## **A63 Castle Street Improvement, Hull**

### **DCO Documents Errata**

- 1.1.1 This Errata lists amendments to the Development Consent Order (DCO) documents which formed the A63 Castle Street Improvement, Hull application submitted to the Planning Inspectorate in September 2018. The Errata focuses upon corrections as opposed to typographical errors. Documents are presented in the order with which they were submitted for DCO.

Volume No: VOLUME 2 FIGURE 2.5.6
 Sheet No: THE SCHEME PROPOSALS - SHEET 5 OF 6

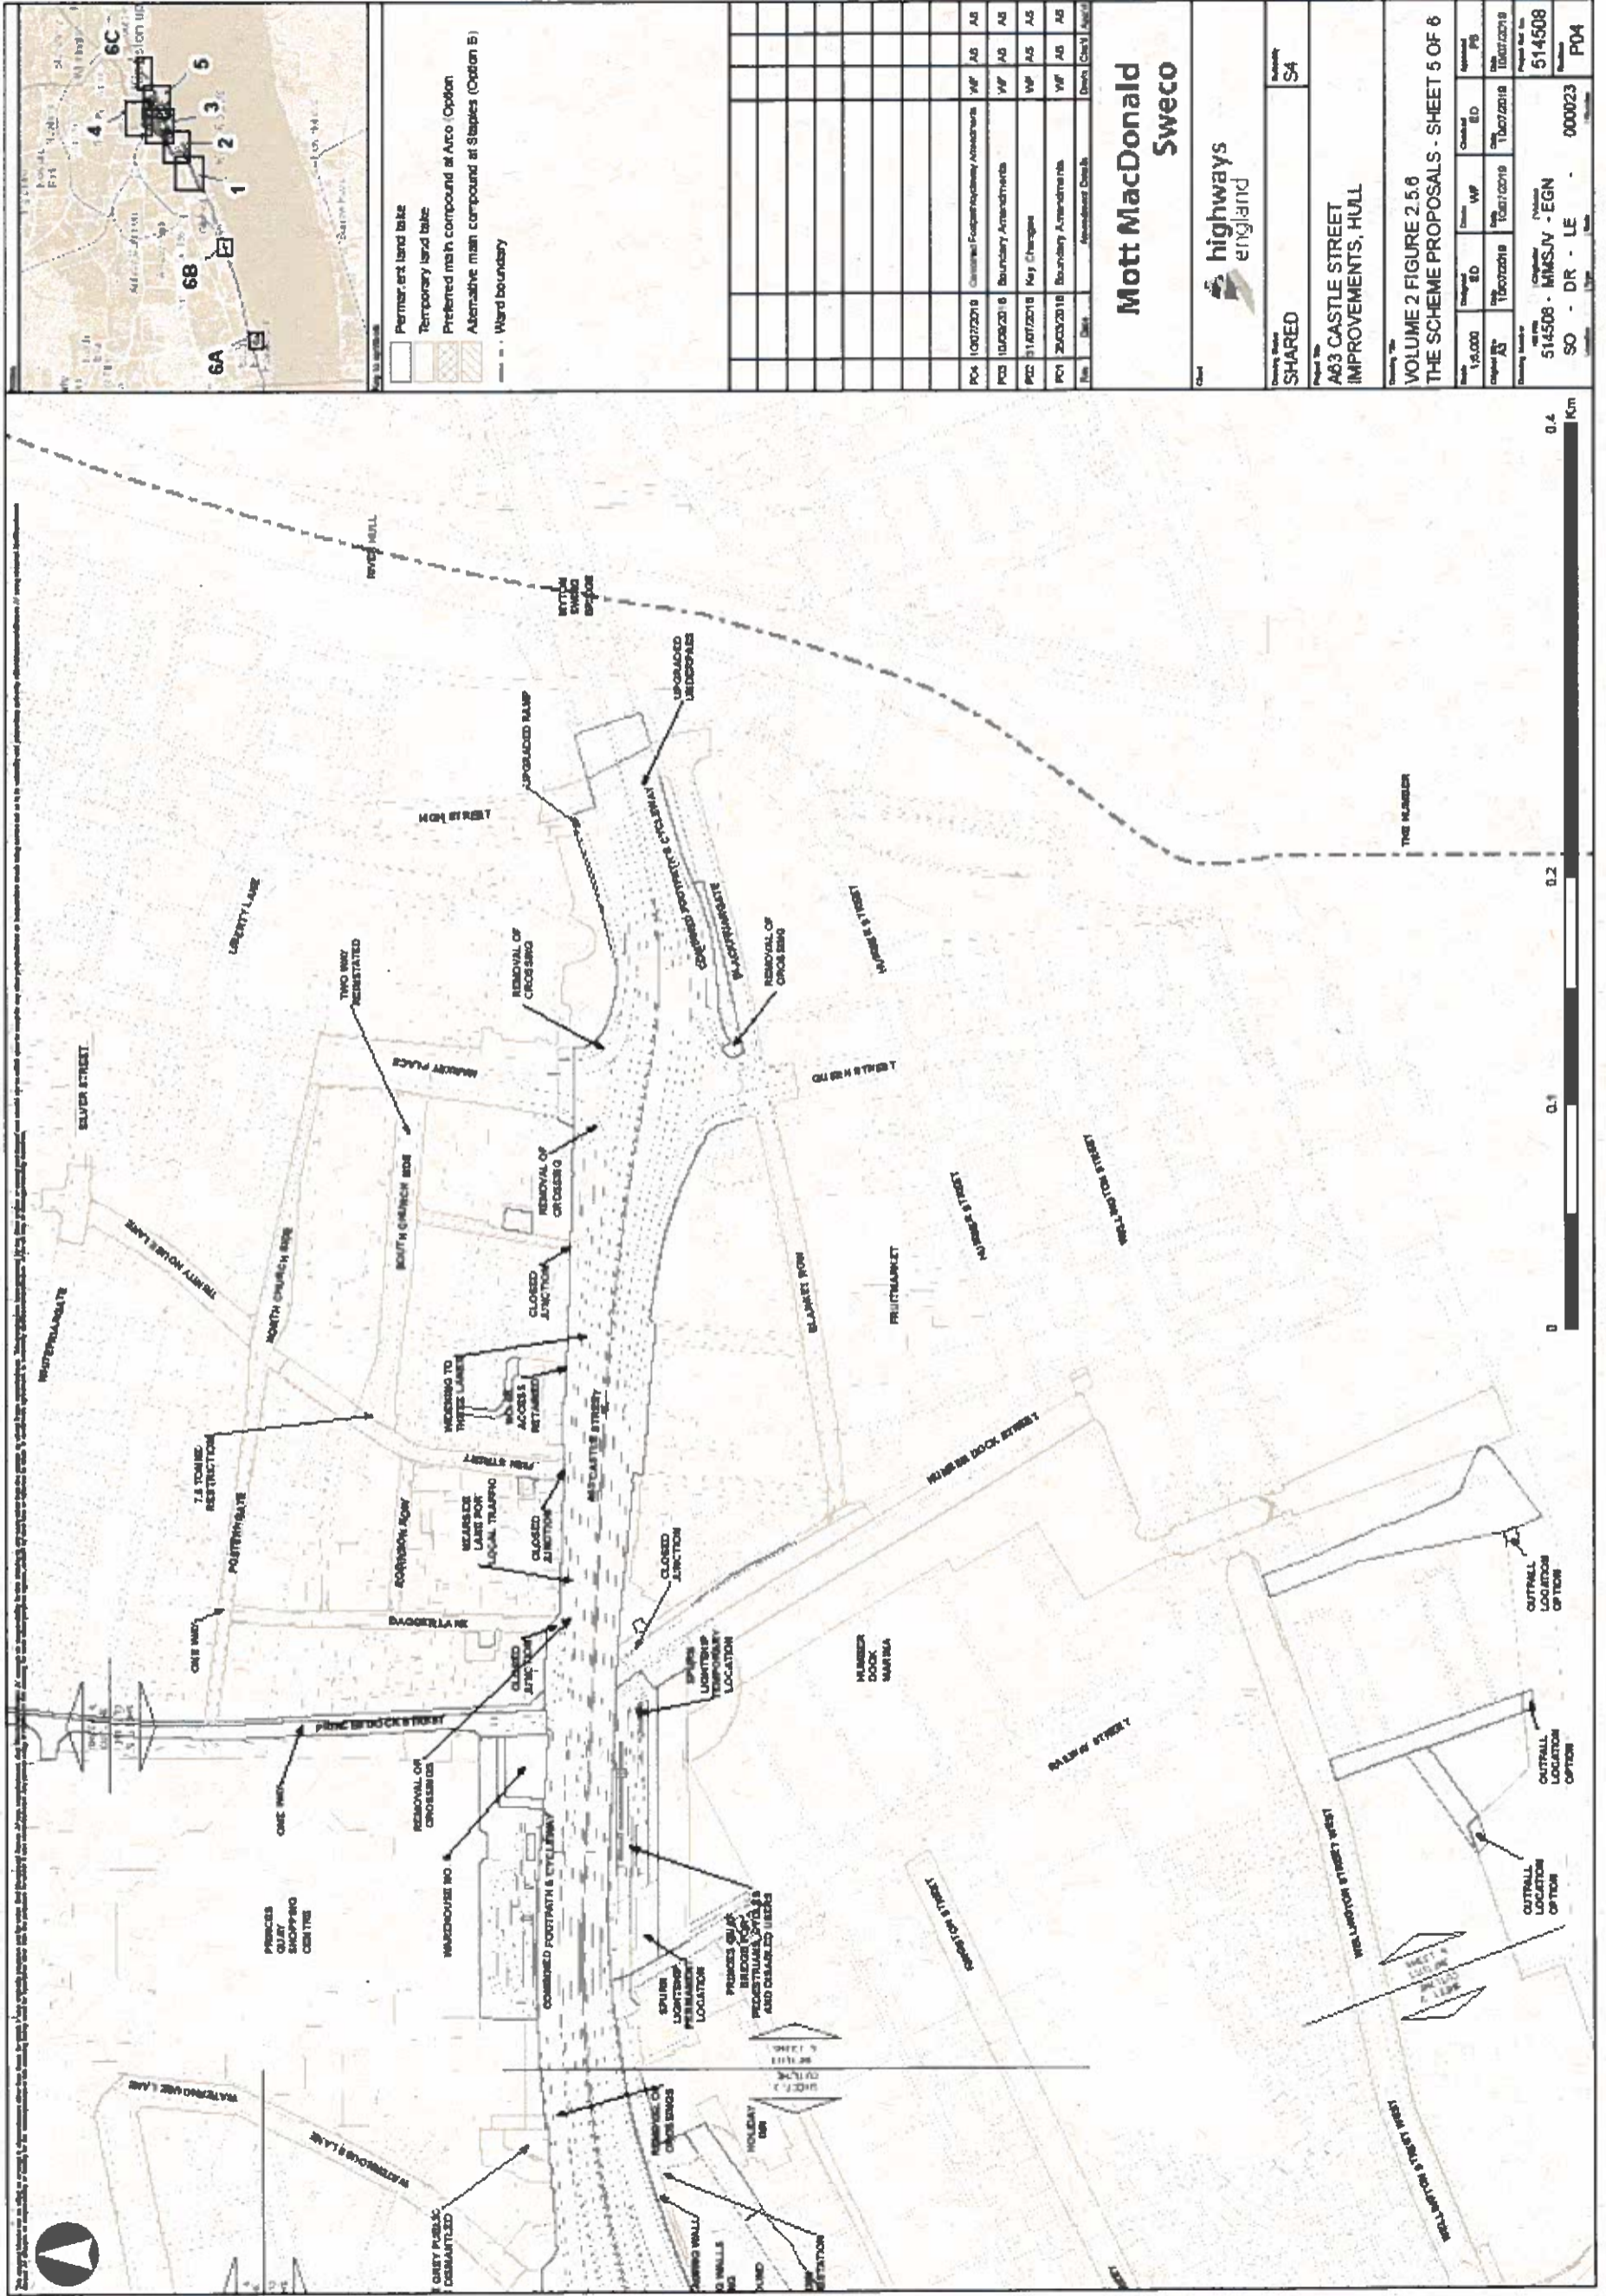
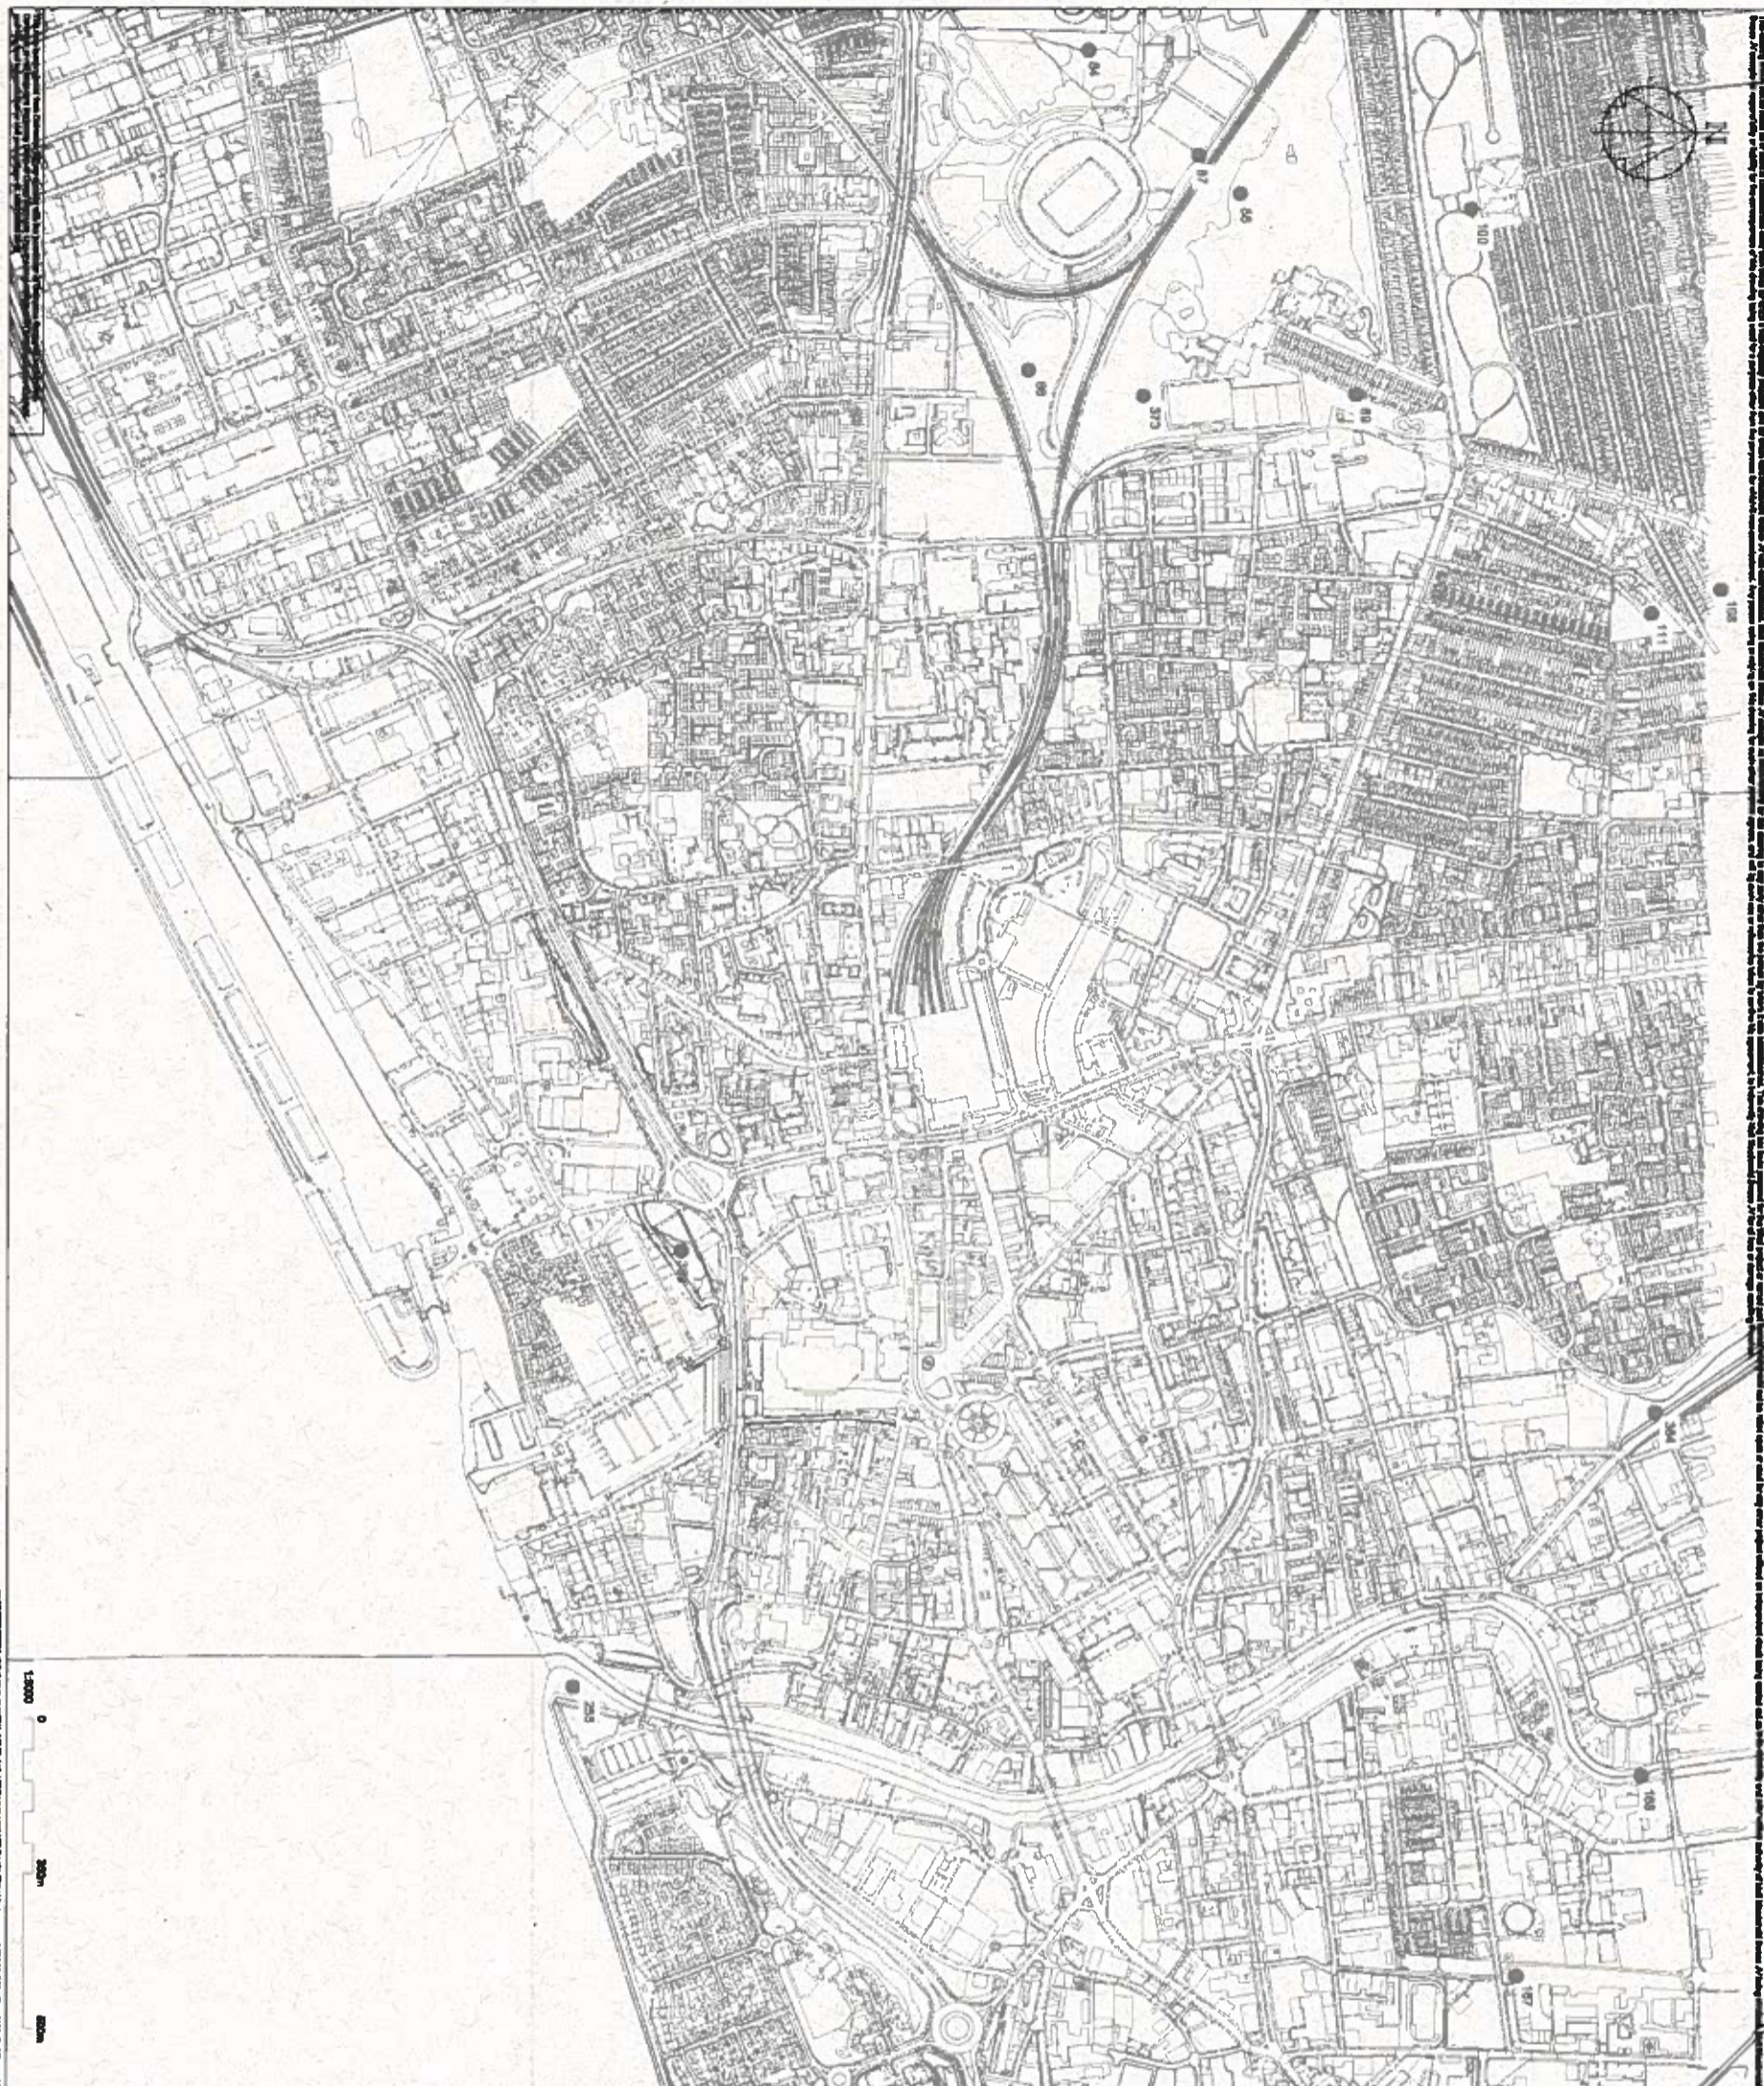
Page	Paragraph/ Table	Published text	Correction				
53	2.6.50	<p>A combined footway and cycleway along the length of both sides of the A63 would be provided as shown on Volume 2, Figure 2.5 Sheets 2, 3 and 5 The Scheme proposals. The shared facility would generally be 3m wide, however there are some locations where space is restricted and the width would be reduced to a minimum of 2m as follows:</p> <ul style="list-style-type: none"> <li>between Castle Buildings and Princes Quay car park on the north side of the A63 for approximately 55m</li> <li>in front of Warehouse No. 6 (Ask restaurant) on the north side of the A63 for approximately 25m</li> <li>in front of Humber Dock Marina, Holiday Inn and Trinity Burial Ground on the south side of the A63 for approximately 400m</li> <li>adjacent to Kingston Retail Park and in front of Arco on the south side of the A63 for approximately 450m</li> </ul>	<p>A combined footway and cycleway along the north side of the A63 and along Blackfriargate would be provided as shown on Volume 2, Figure 2.5 Sheets 2, 3 and 5 The Scheme proposals. The shared facility would generally be 3m wide, however there are some locations where space is restricted and the width would be reduced to a minimum of 2m as follows:</p> <ul style="list-style-type: none"> <li>in front of Castle Buildings for approximately 25m</li> <li>from Castle Buildings east to the rear of Princes Quay car park for approximately 122m</li> <li>from Castle Buildings west to the end of the Earl de Grey public house for approximately 55m</li> </ul>				
66	2.9.6	There is no traffic management requirement for phase 0.	Delete text				
317	Table 10.4 Non-statutory designated sites (row 13)	<table border="1"> <tr> <td>SNCI</td> <td>Foredyke stream cycle track - south of Chamberlain Road (177)</td> <td>No information provided</td> <td>1.6km northeast</td> </tr> </table>	SNCI	Foredyke stream cycle track - south of Chamberlain Road (177)	No information provided	1.6km northeast	Remove row 13 from table
SNCI	Foredyke stream cycle track - south of Chamberlain Road (177)	No information provided	1.6km northeast				
335	Table 10.8 Summary of valuation of ecological receptors, Ecological receptor column (row 3)	Trinity Burial Ground SNCI, River Hull SNCI	Trinity Burial Ground SNCI, River Hull SNCI, Mudflats to the south of Sammy's Point SNCI				
340	10.7.17	<p><u>River Hull SNCI</u> Direct impacts to the River Hull SNCI are unlikely.</p>	<p><u>River Hull SNCI and Mudflats to the south of Sammy's Point SNCI</u> Direct impacts to the River Hull SNCI and Mudflats to the south of Sammy's Point SNCI are unlikely.</p>				
347	10.7.54	<p><u>River Hull SNCI</u> Road drainage would not discharge to the River Hull during the Operation Phase and there would therefore be no risks to water quality within the river.</p>	<p><u>River Hull SNCI and Mudflats to the south of Sammy's Point SNCI</u> Road drainage would not discharge to the River Hull during the Operation Phase and would not impact upon the River Hull SNCI or Mudflats to the south of Sammy's</p>
